W-2011-39  
March 24, 2016

**Re: Proposed Parking Lot Improvements – Whole Foods Market  
160 Fox Street, Portland, Maine**

**Level I Site Plan Development Review Application**

**A. Reviewer: Woodard & Curran  
Date: March 17, 2016**

LANDSCAPE PLAN

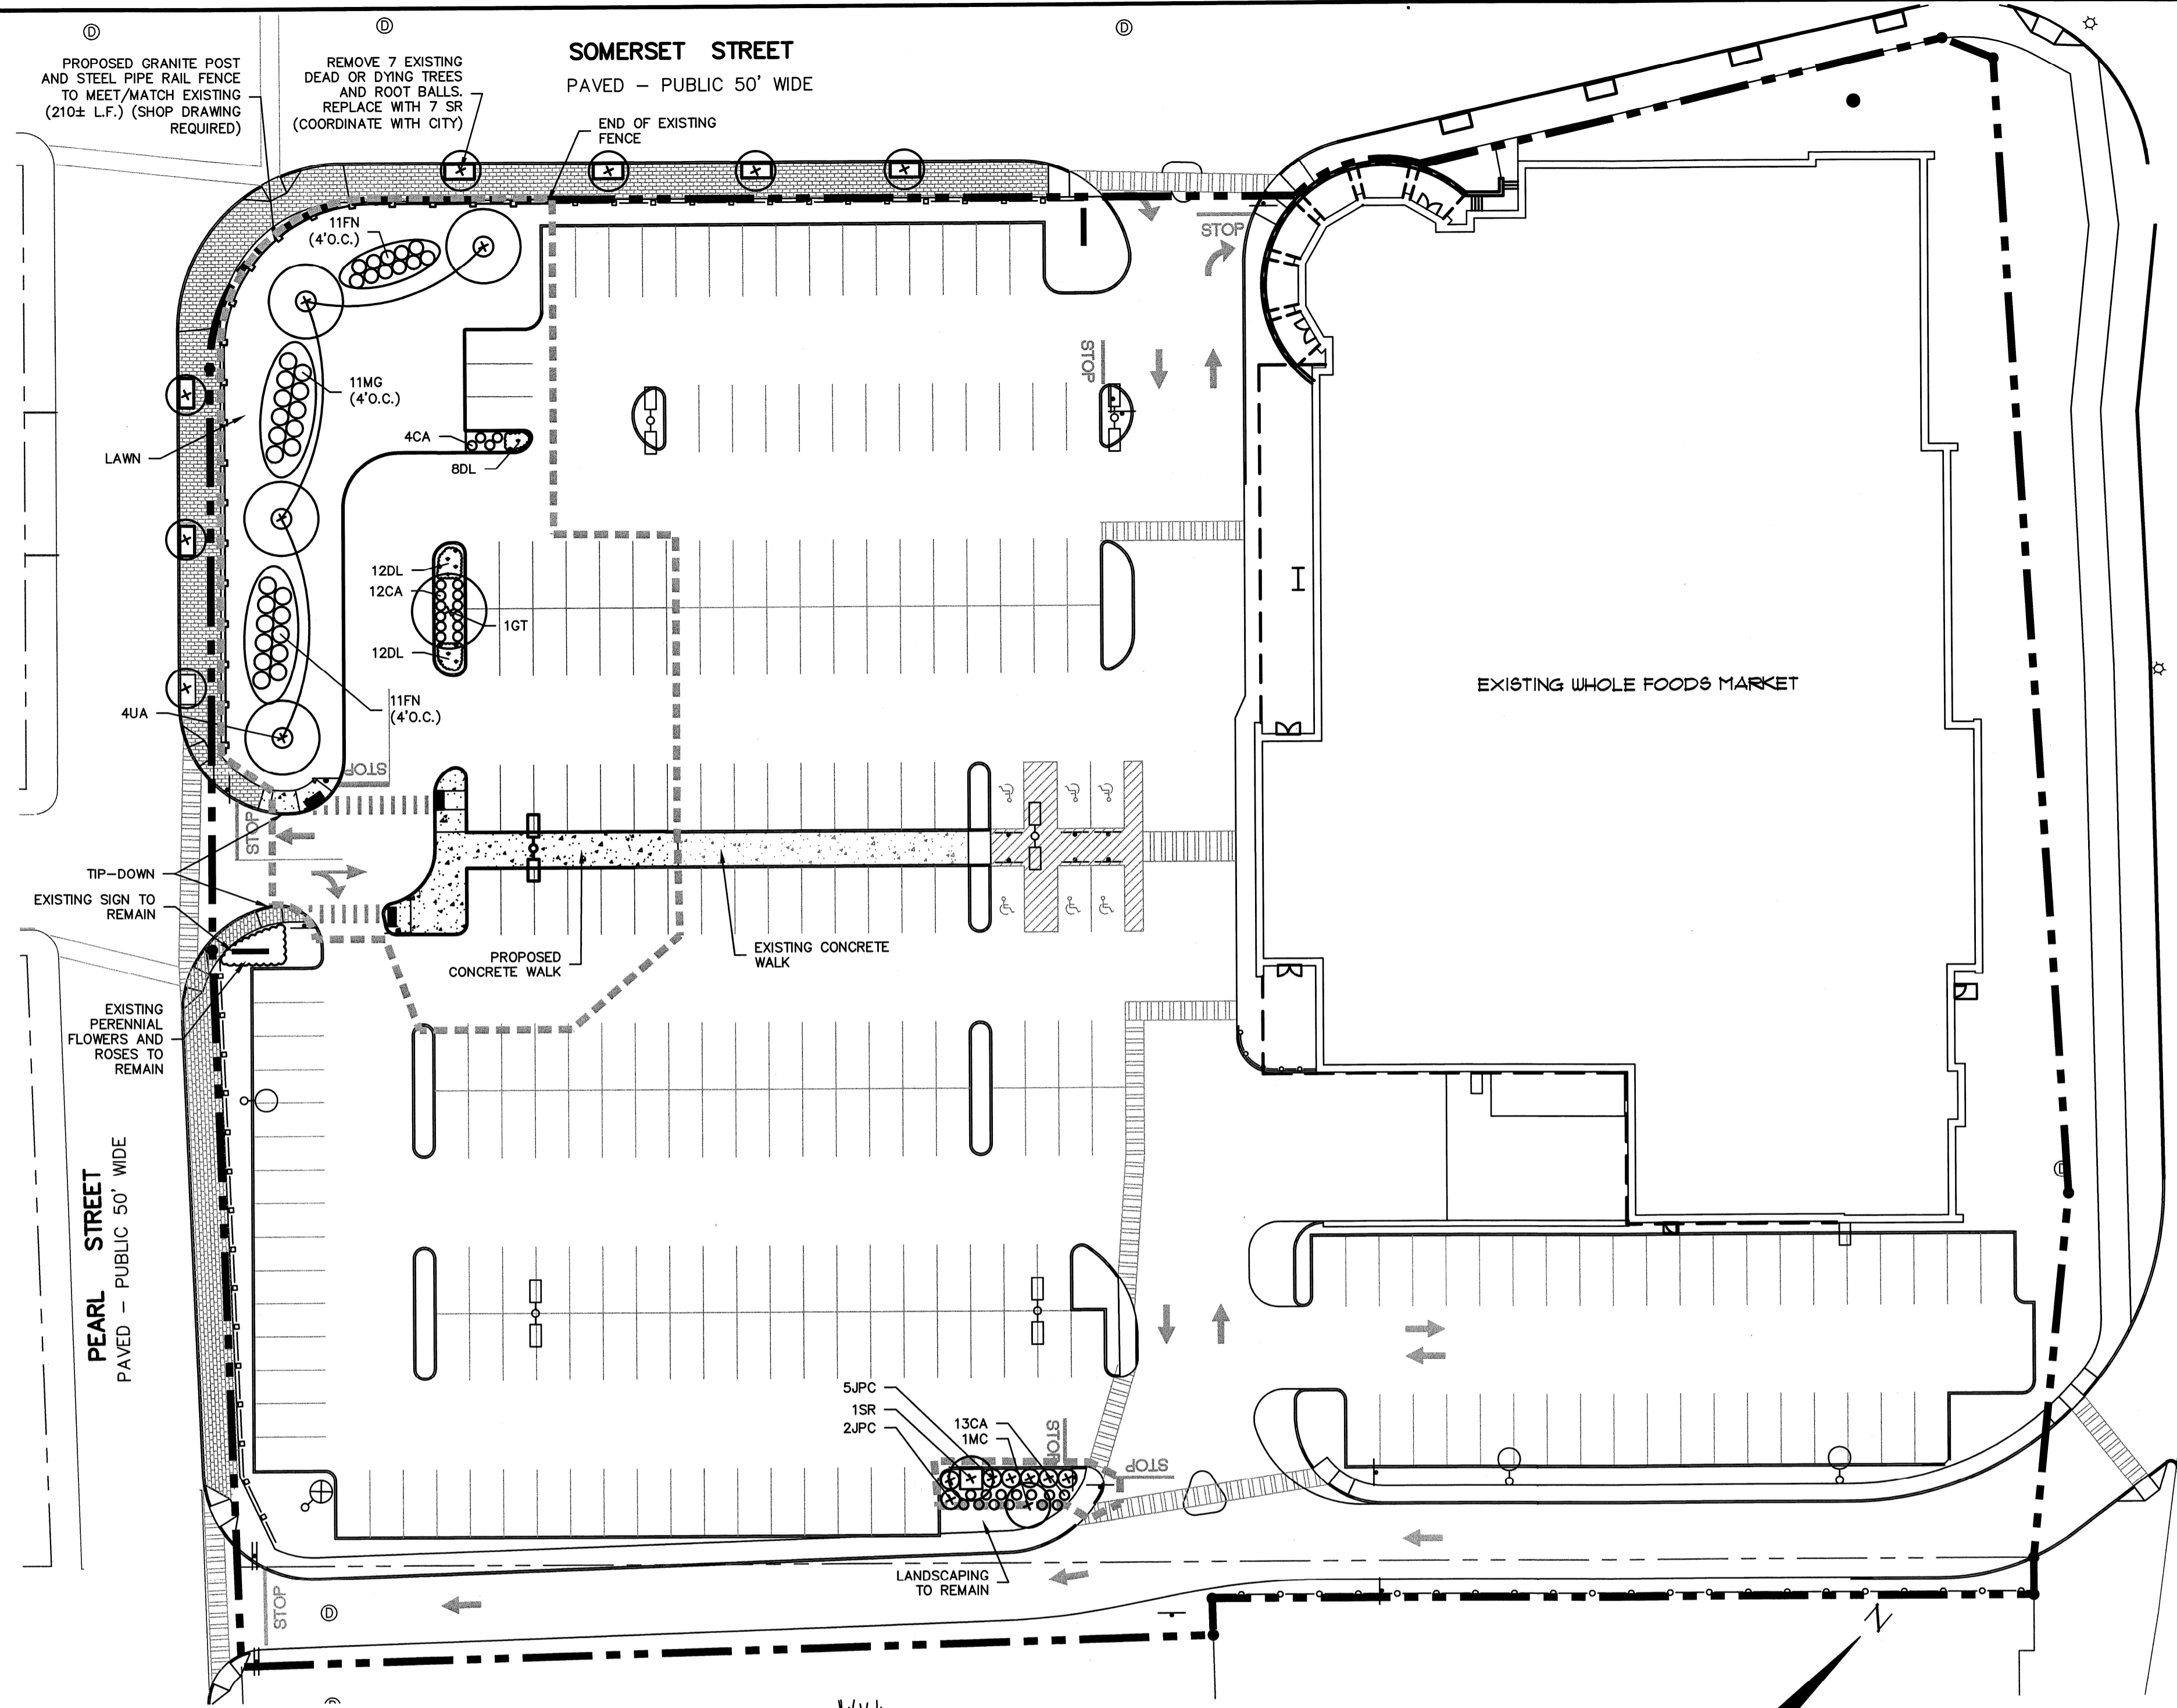
1. *The City arborist wanted to see additional plantings in the green island in the expanded parking area.*

**Additional plantings have been proposed.**
